**Defence
Infrastructure
Organisation**

Your reference: TR02002

Application by River Oak Strategic Partners for an Order granting Development Consent

MOD Safeguarding Manston Airfield

4.05 Uses - Cargo Area

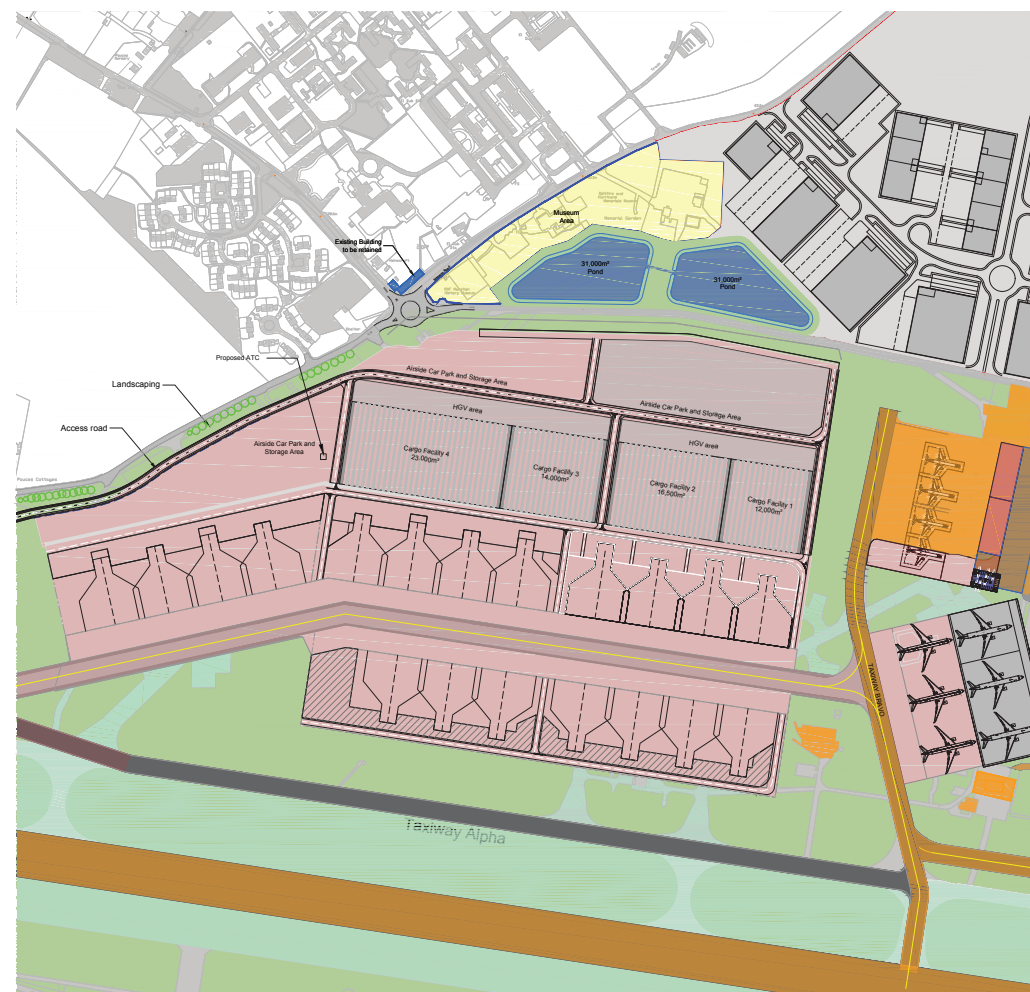
Cargo buildings approx. 25m above ground level – almost 600m wide, broadside to the HRDF and only 410m distant.

Aircraft parking – commercial jet aircraft within 100m.

ATC 24m above ground level – not as bad as the first two but about 60m on a side and 460m distant.

The plan is not compatible with continued functioning of HRDF at current height and position.

The problem is not the restriction heights but that they are broken by such a huge amount in height, breadth and proximity. There would be massive obscuration to the north and bearing errors from reflection of signals originating south.

In summary it is mainly the development immediately north and west of the HRDF which is of concern to the MoD and determined our objection response.
